Development Control
Ribbles Valley Borough Council

Re: Planning Application 21/0112

Address: 2 St Johns Close Read BB12 7RL

Description: Proposed two bedroom dwelling.

Proposed Dwelling
EXISTING SITE LAYOUT

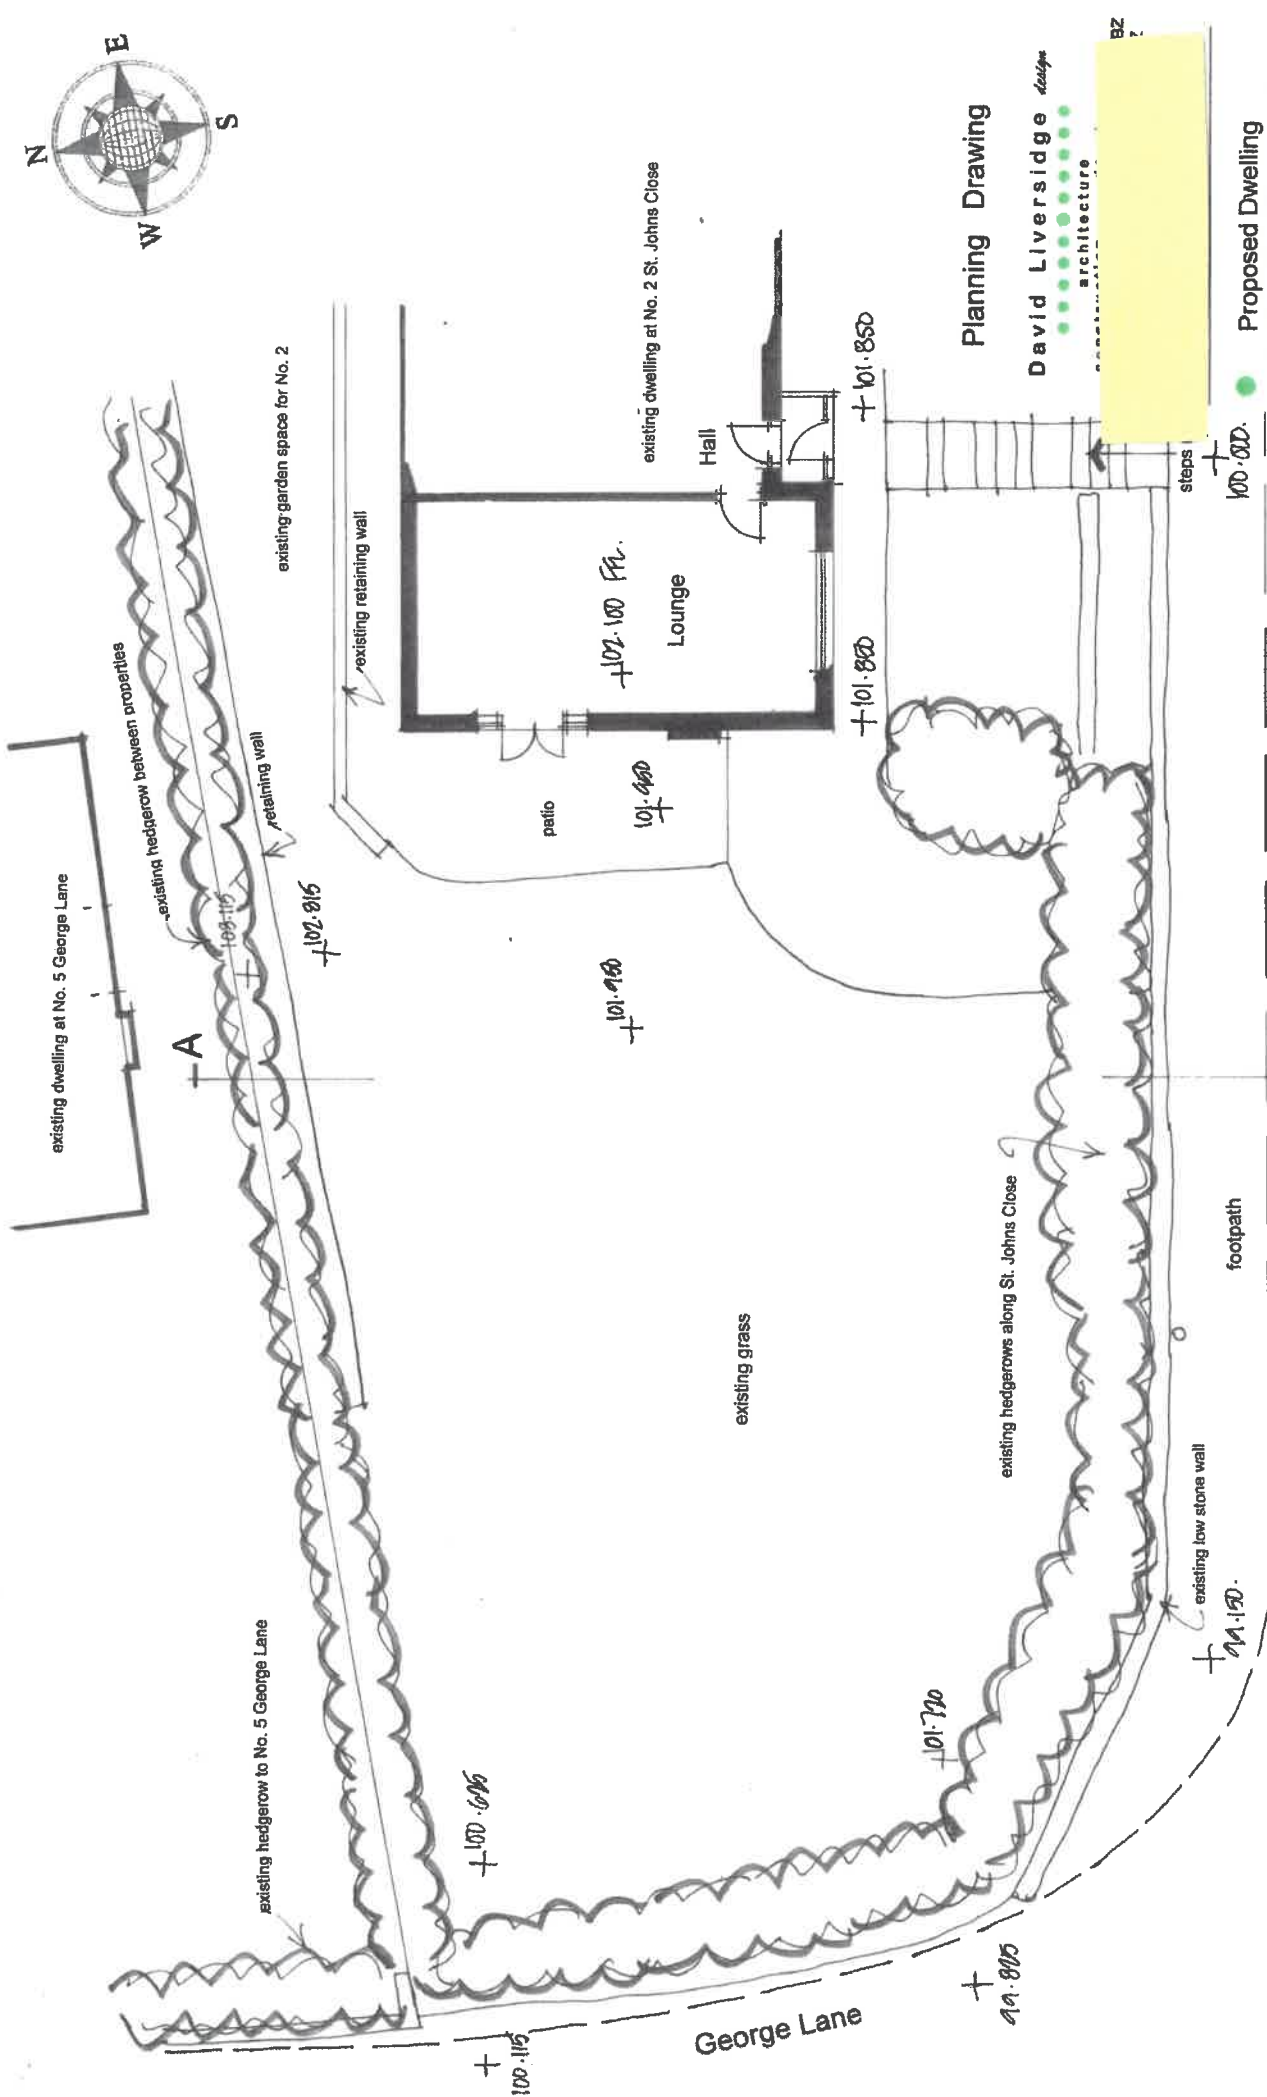
There is a grave concern regarding the lack of visibility from the proposed driveway to the north of the access. The situation is exasperated by the curvature of the road and the downhill slope of approximately 1 in 15 that fall across the proposed access.

Manual for Street would suggest that a visibility splay measuring 2.4m x 25m should be provided for a road with a 20 m.p.h. limit.

In order to progress the application we would look for further submissions allaying our concerns over the lack of visibility.
